DRB Application No.: <b>09DRB-70208</b>	Project # <b>1006687</b>
Project Name: <b>NORTH ALBUQUERQUE ACRES TO BE KNOWN AS EAGLE'S PERCH UNIT 3</b>	
Agent: <b>ADIL RIZVI</b>	Phone No.:

**RE: Lots 11 & 12, Block 3, North Albuquerque Acres Tract  
3, Unit 3**

**Subdivision:** Eagle's Perch Unit 3

The purpose of this plat is to replat two existing lots into five residential lots, dedicate public right of way and grant easements.

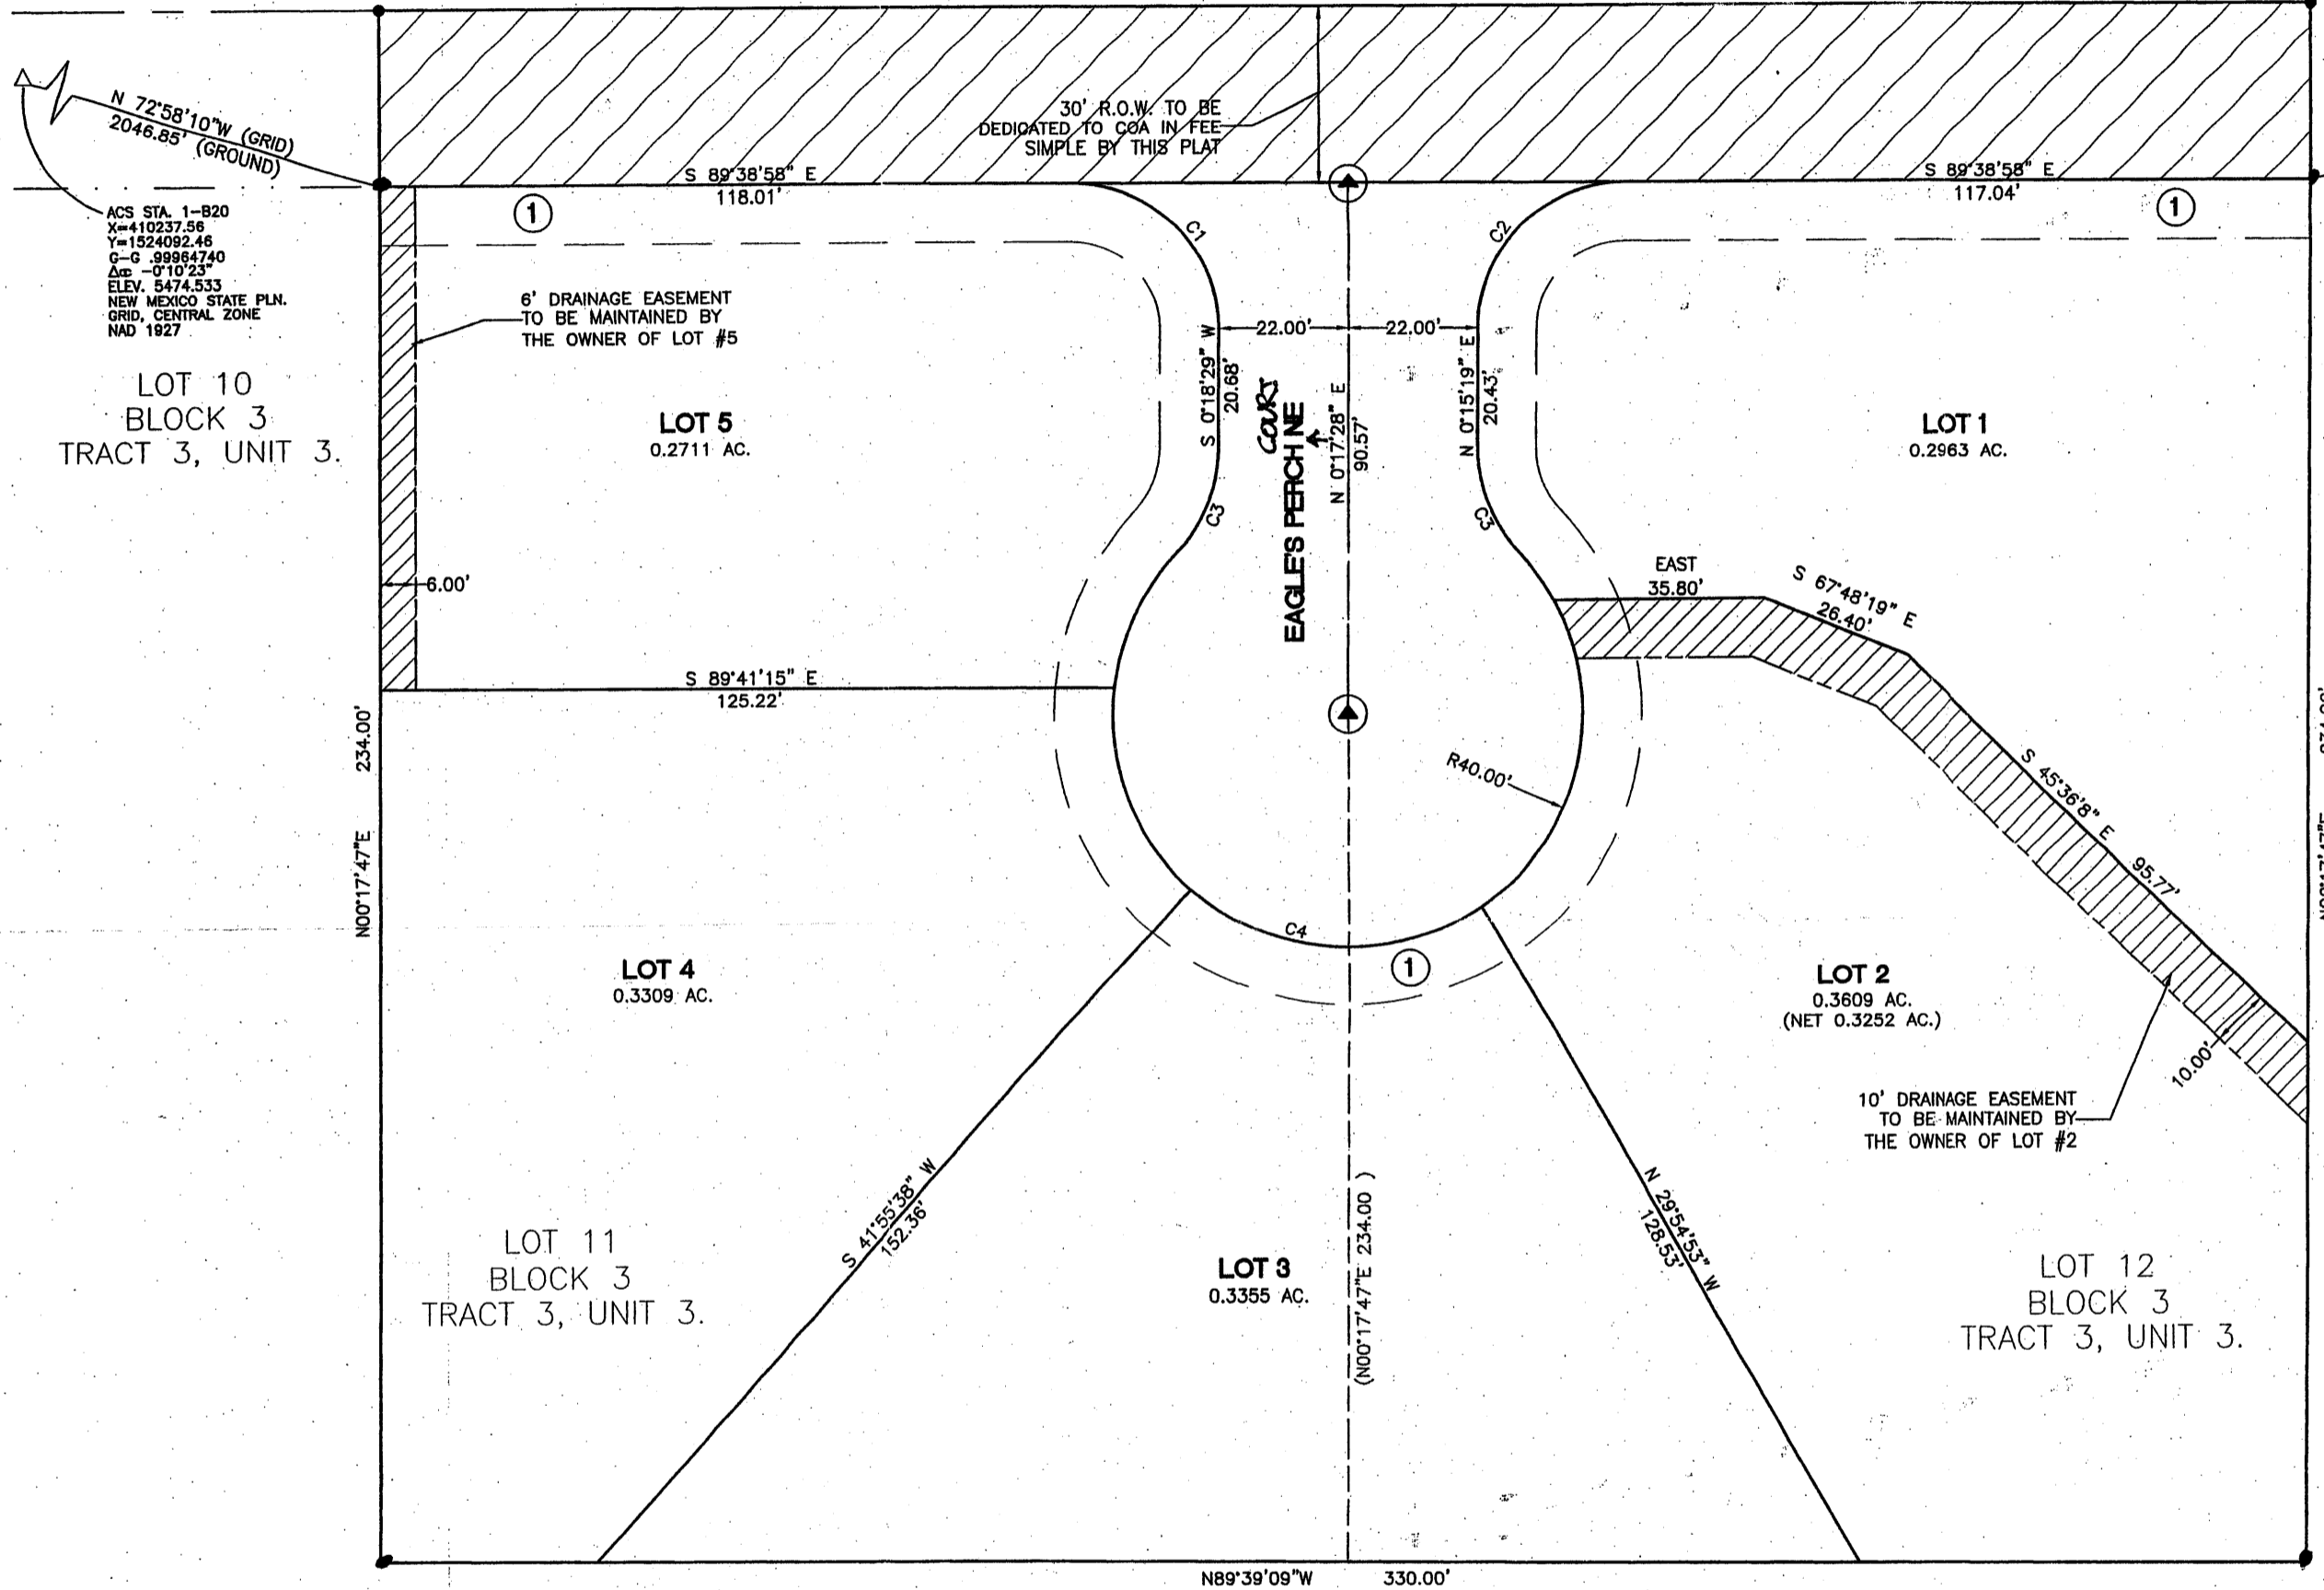
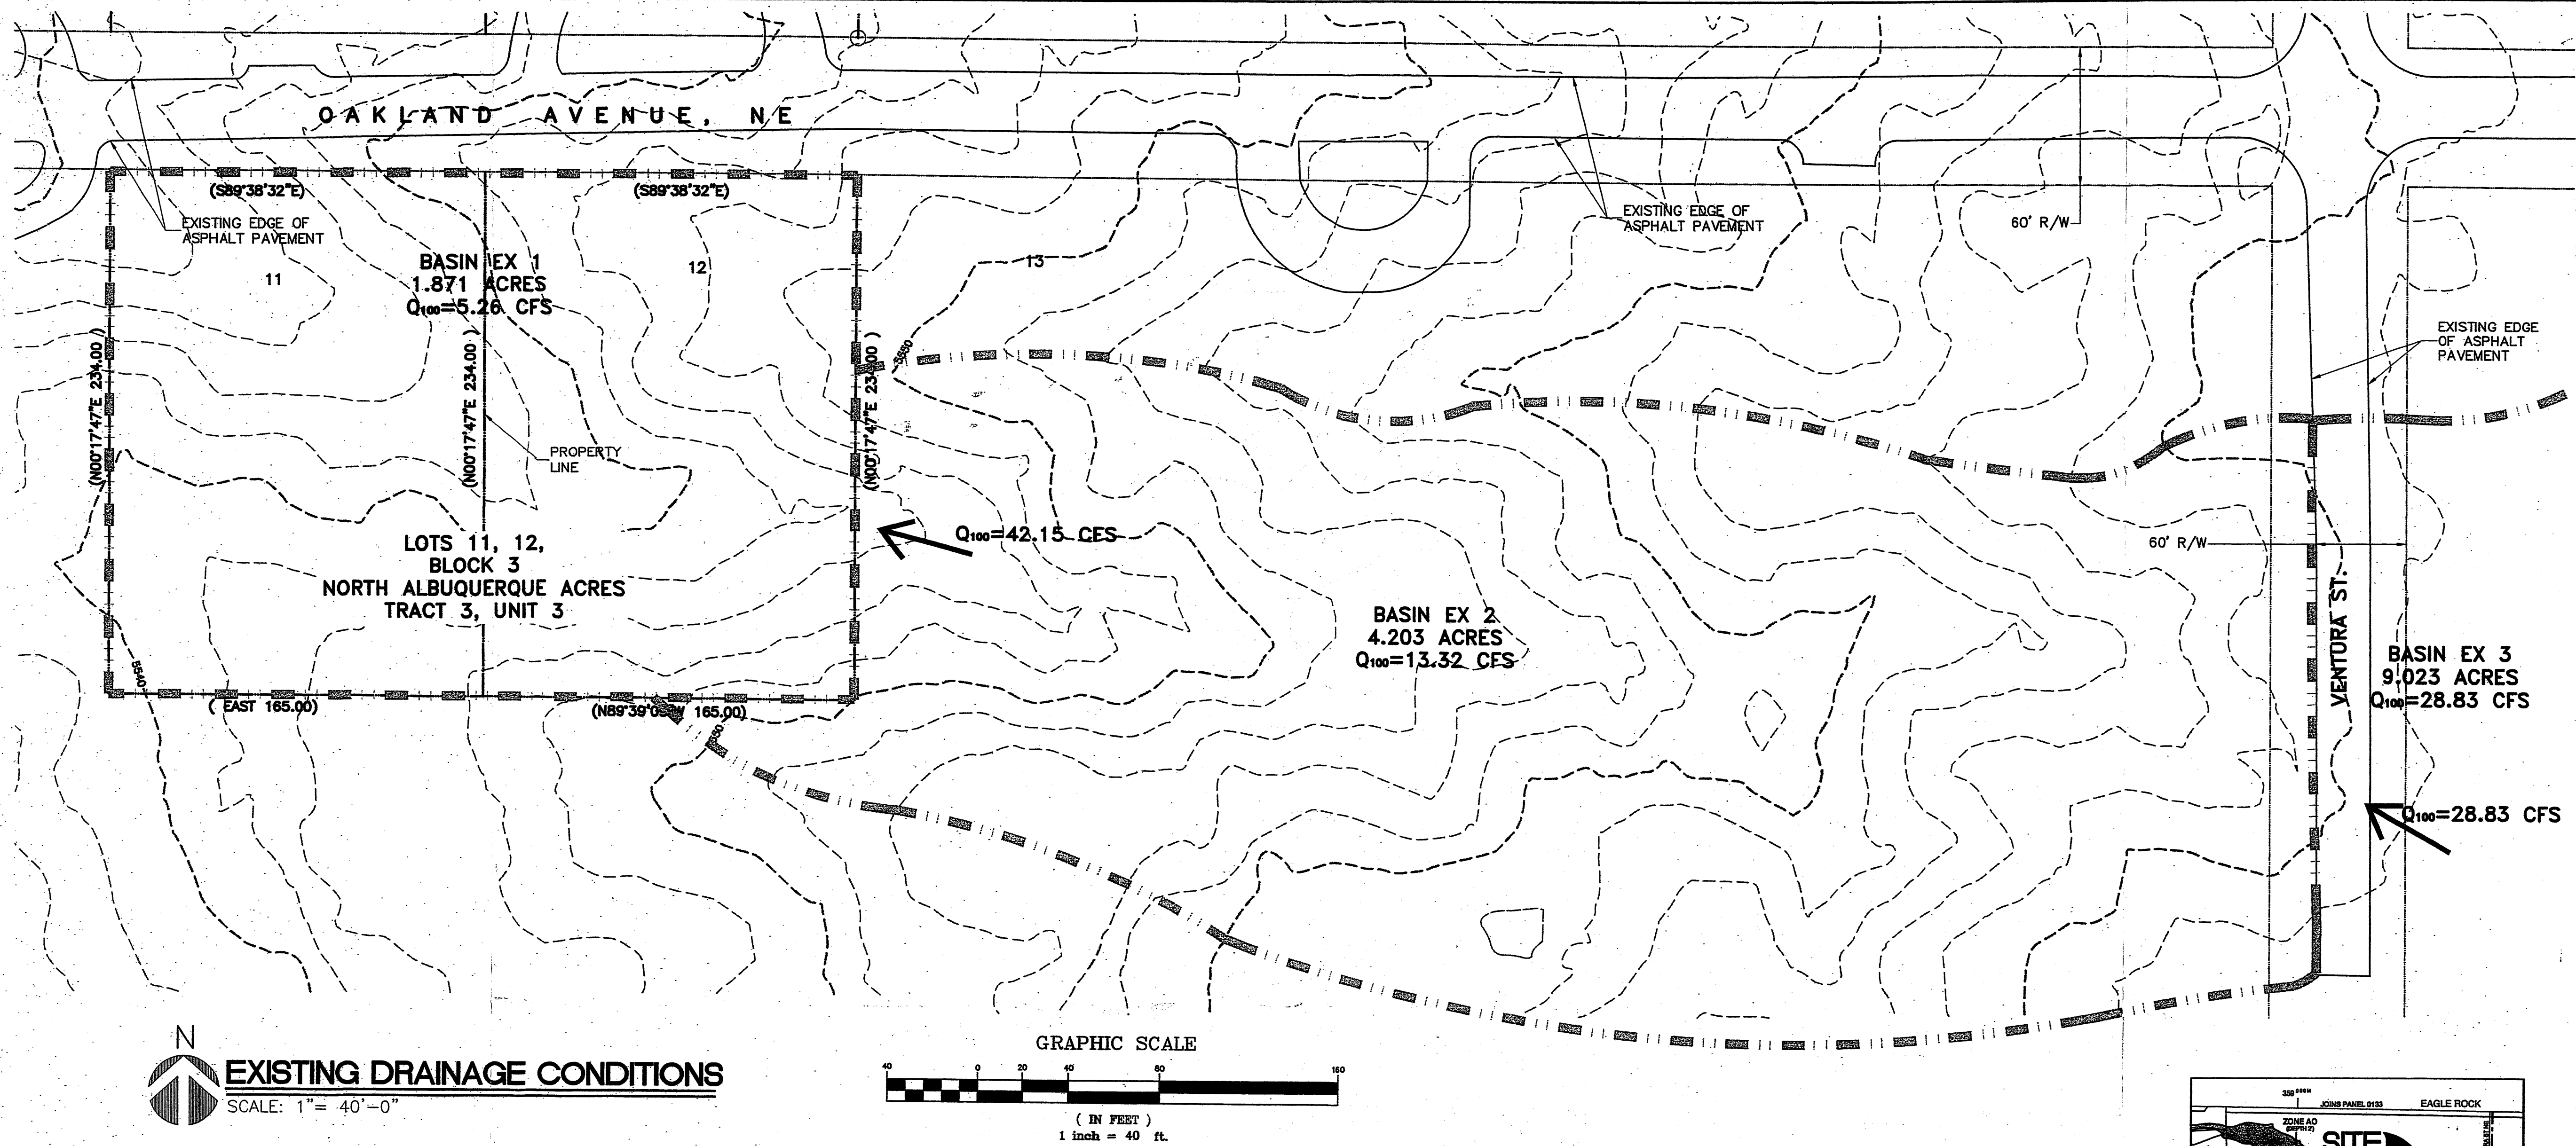
Provide an exhibit showing the location of sidewalk and defining the distance from face of curb to the property line. Right of way dedication may be required.

The proposed right of way dedication does not comply with the standard detail for a cul-de-sac. Please refer to City of Albuquerque Standard Number 2510.
